Our Ref: A/85/18/RES
Your Ref:

Application for Approval of Reserved Matters Following Outline Approval

Development Approval of reserved matters for appearance, landscaping, layout & scale following outline consent A/131/16/OUT for 9 No one & a half storey houses with garaging, including 3 No. affordable housing units.

Location Land between New Place Bungalow and Arundel Road Angmering

ELEVATIONS: 1/100
UNIT:1

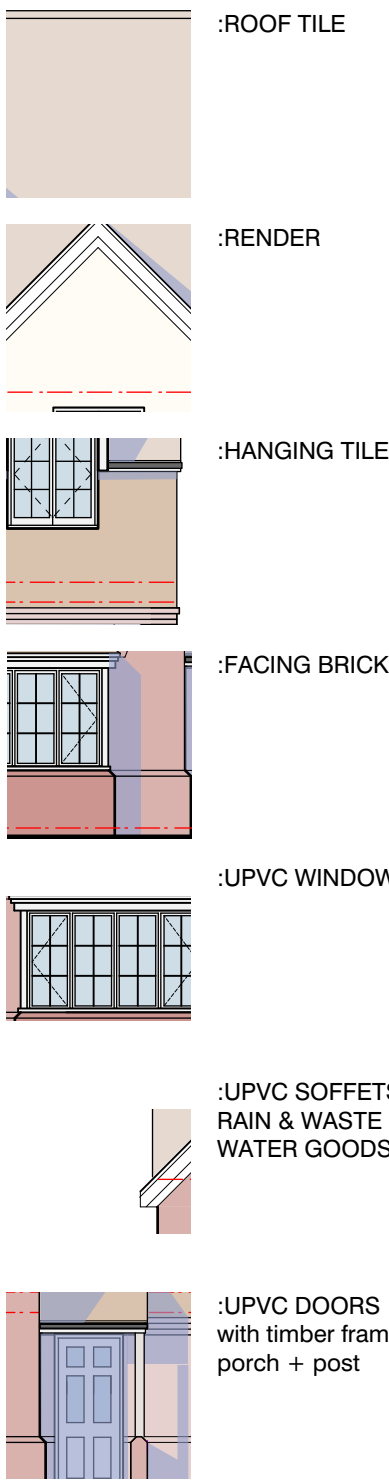
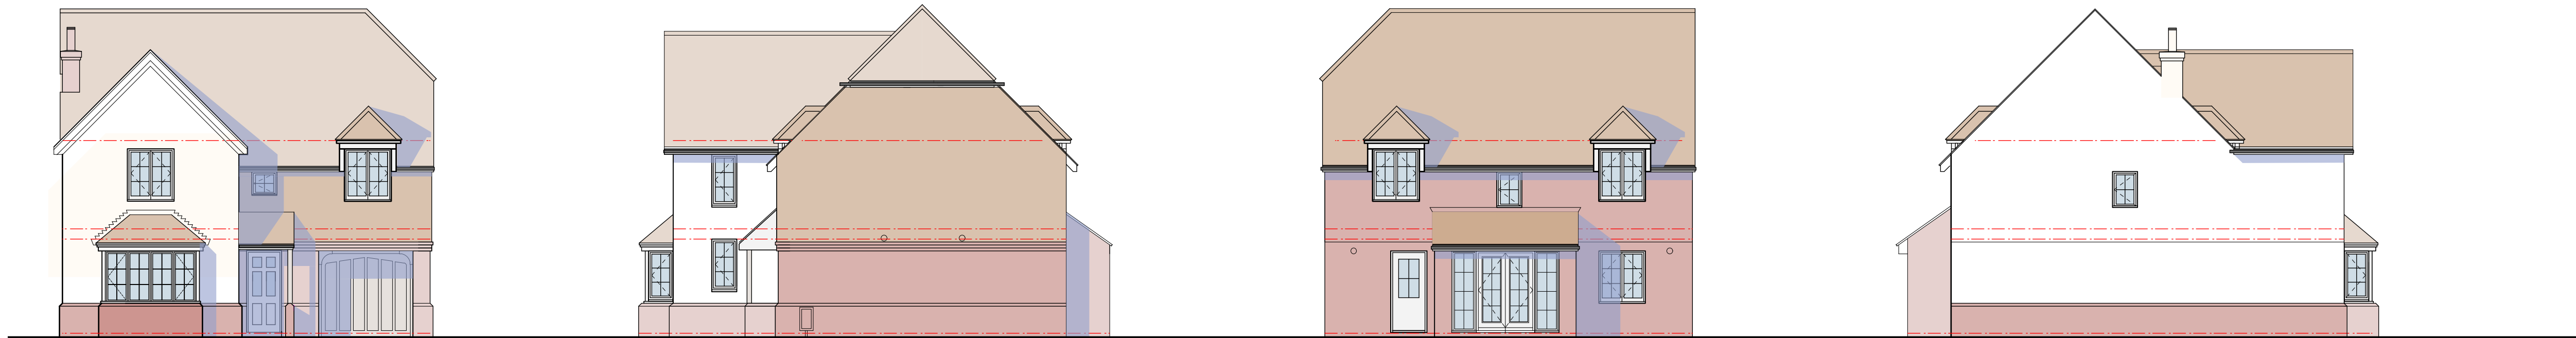
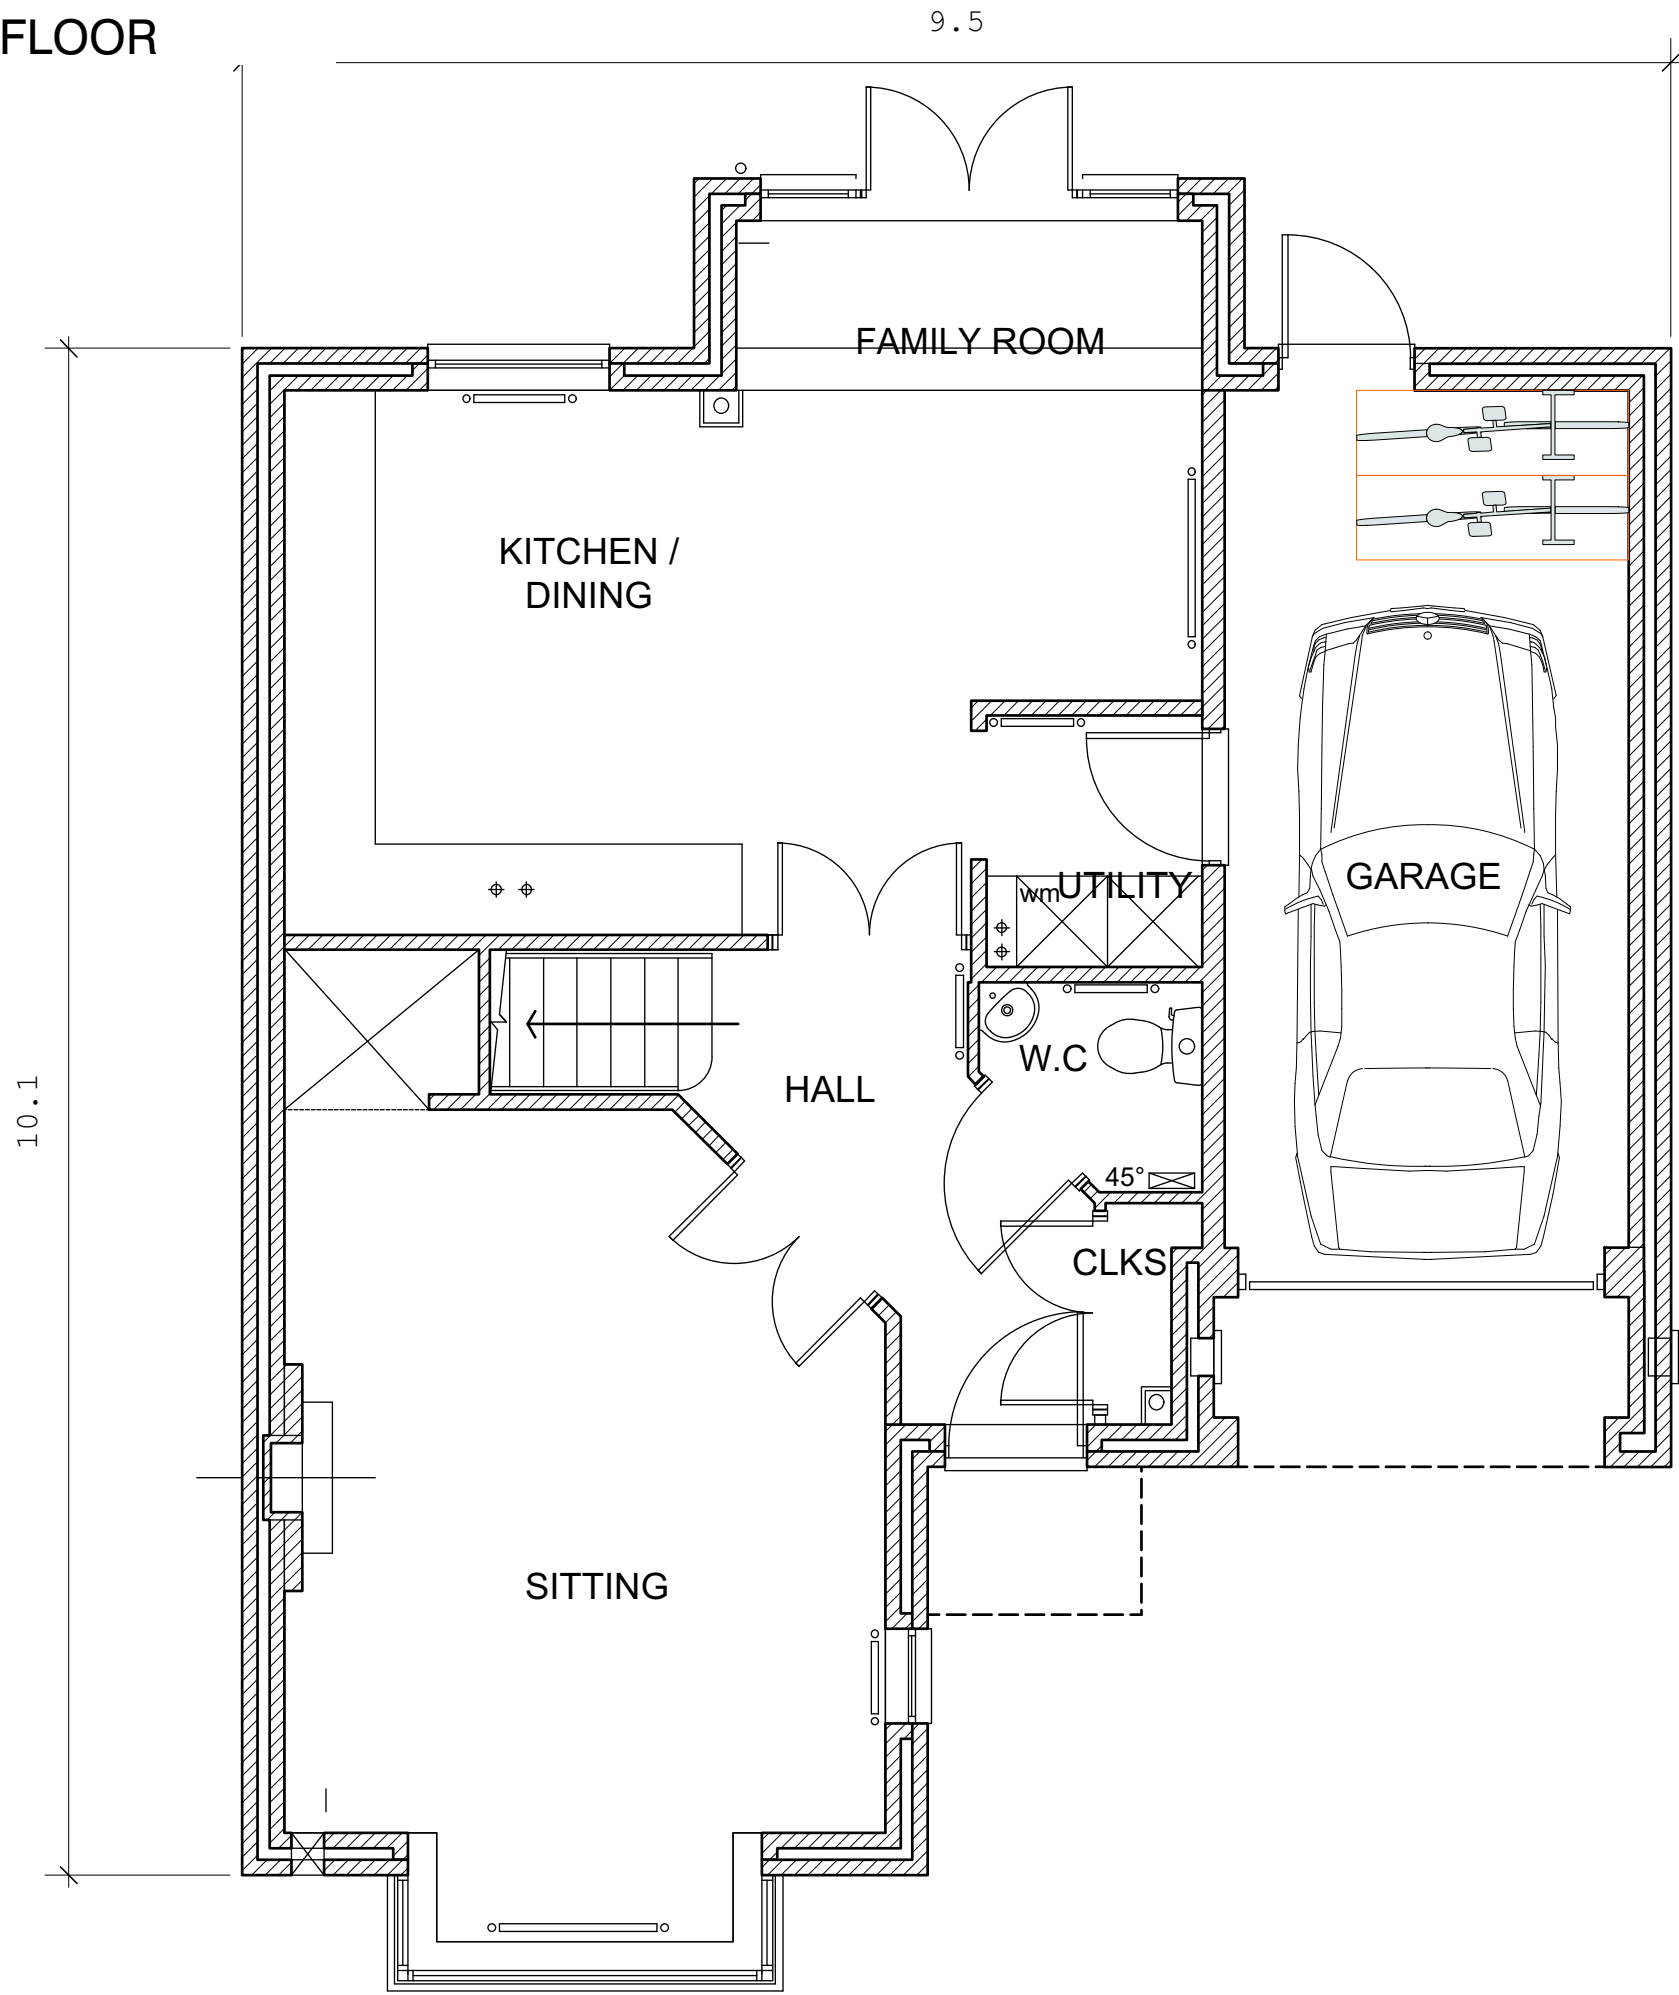
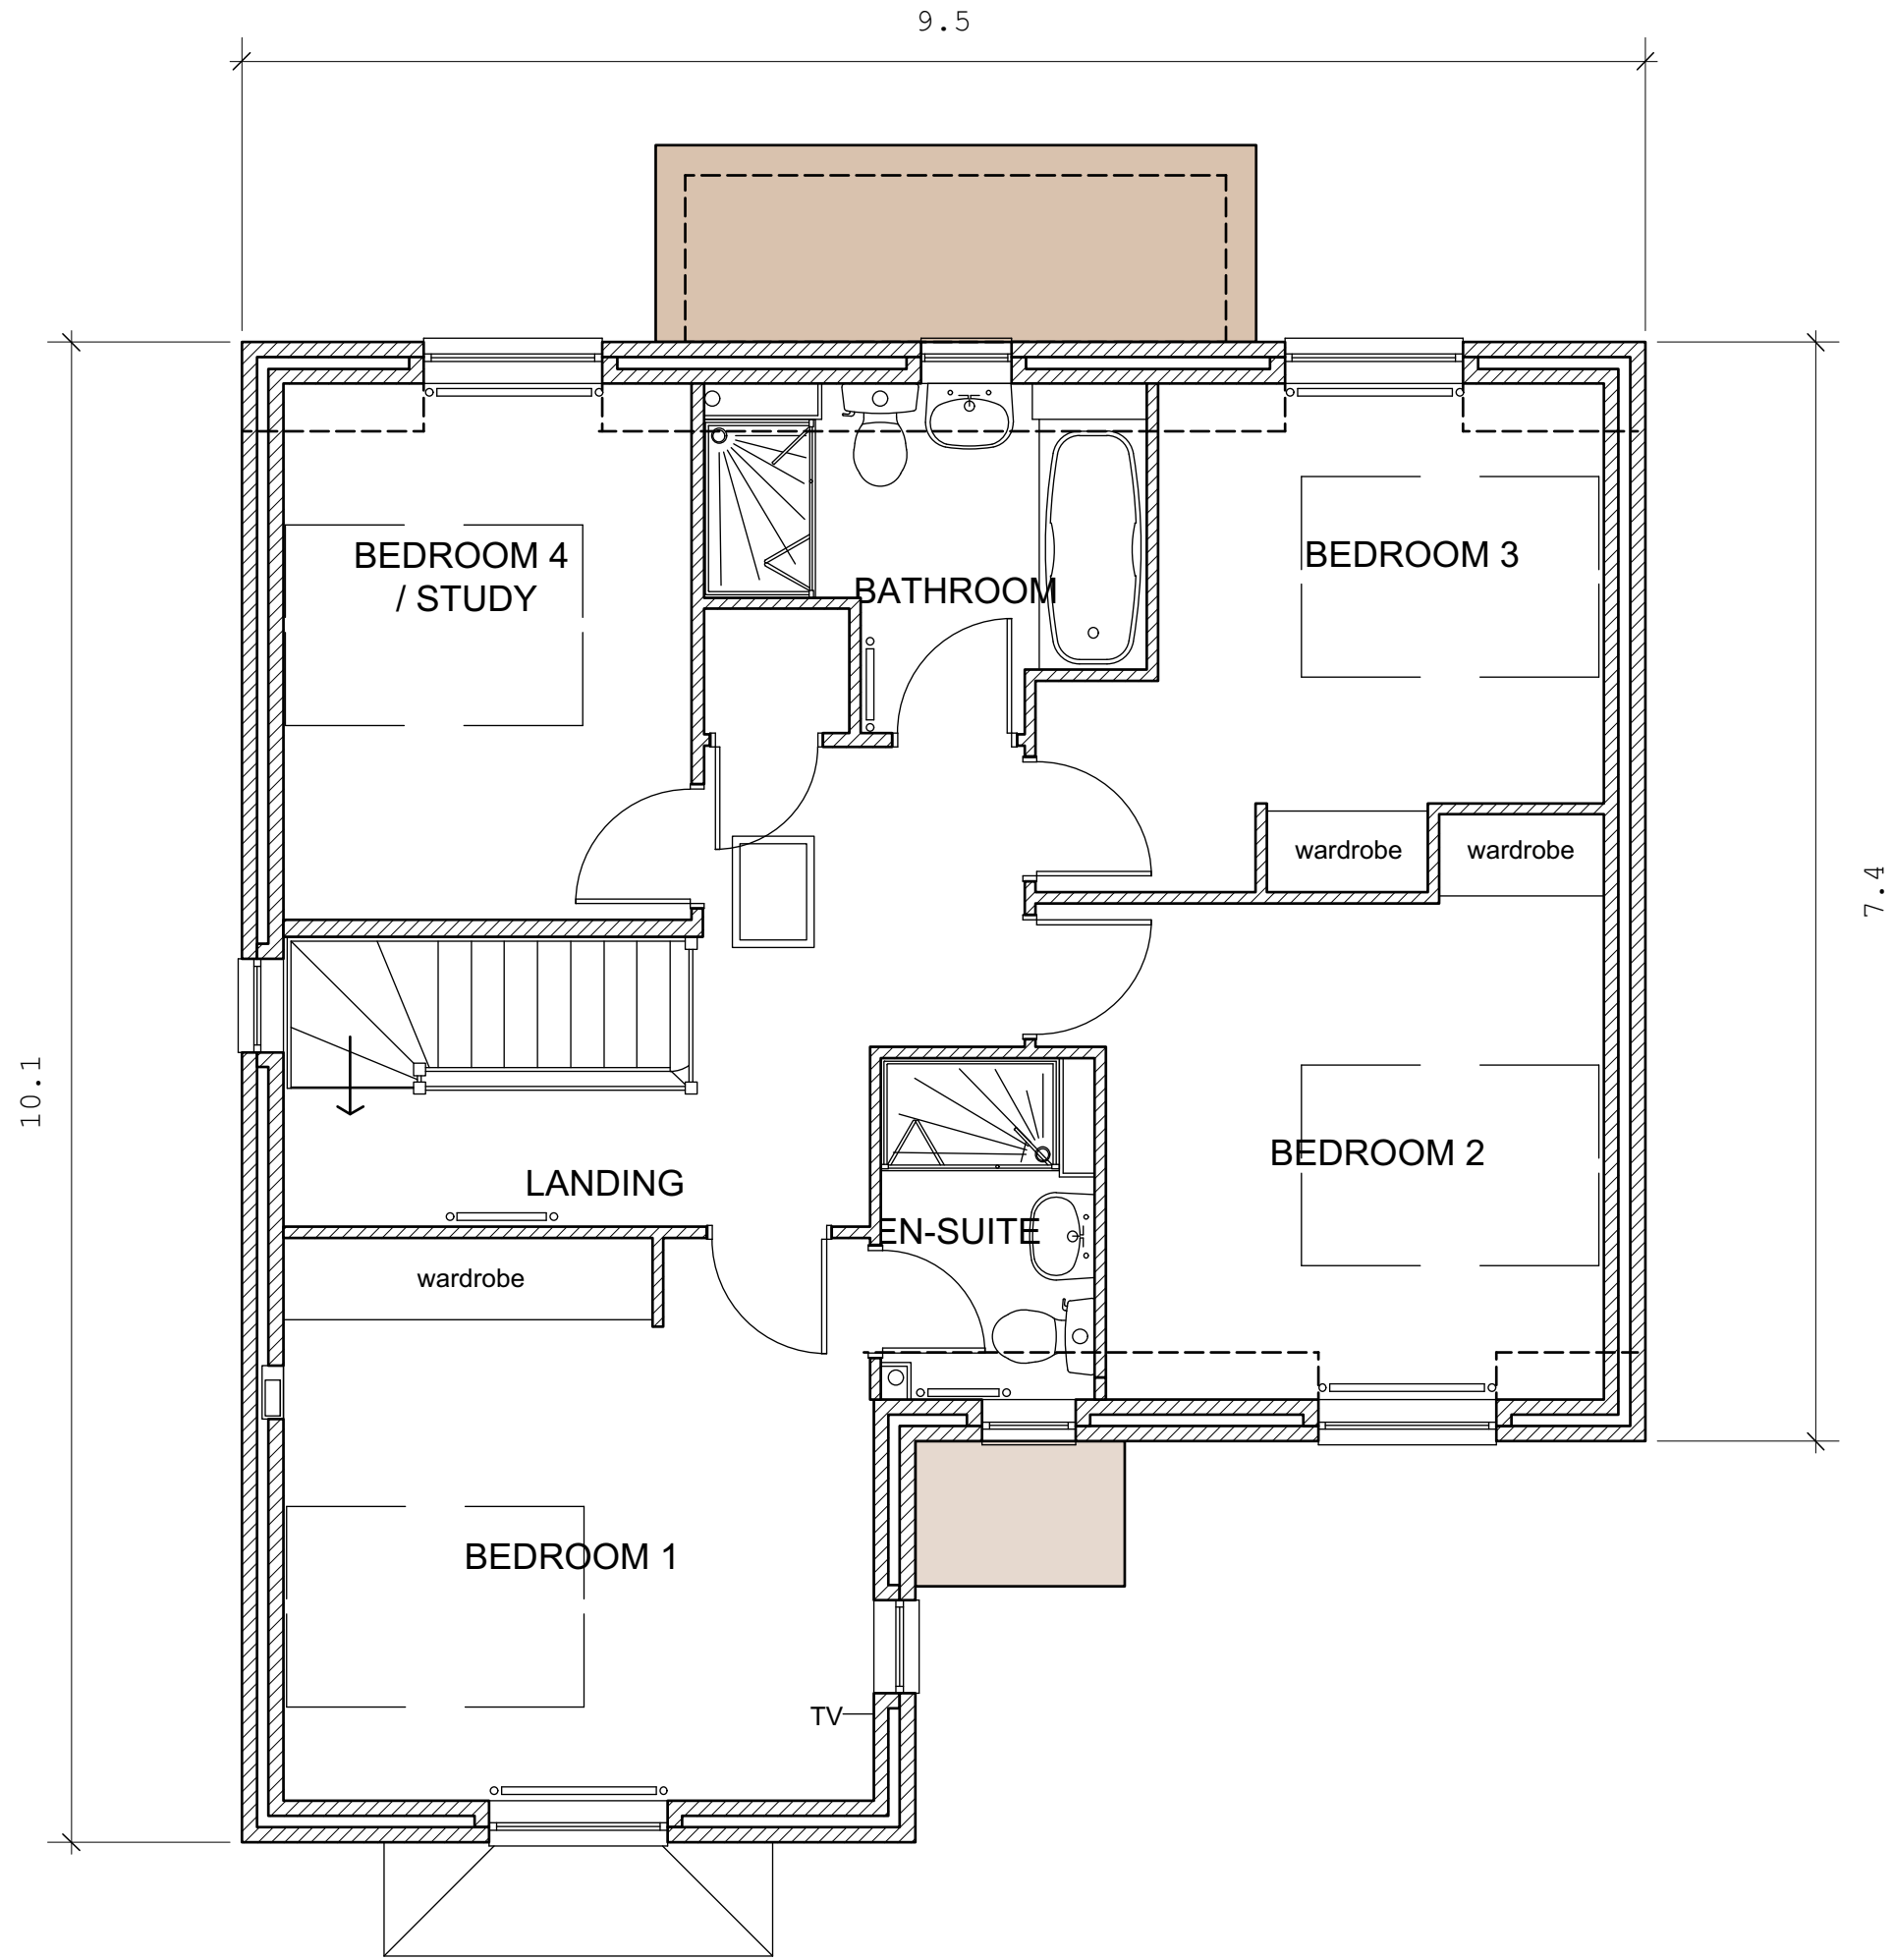
The plan, Unit D shows elevations for plot 4 and does not match the other plot 4, on plan Unit C. Please amend accordingly.
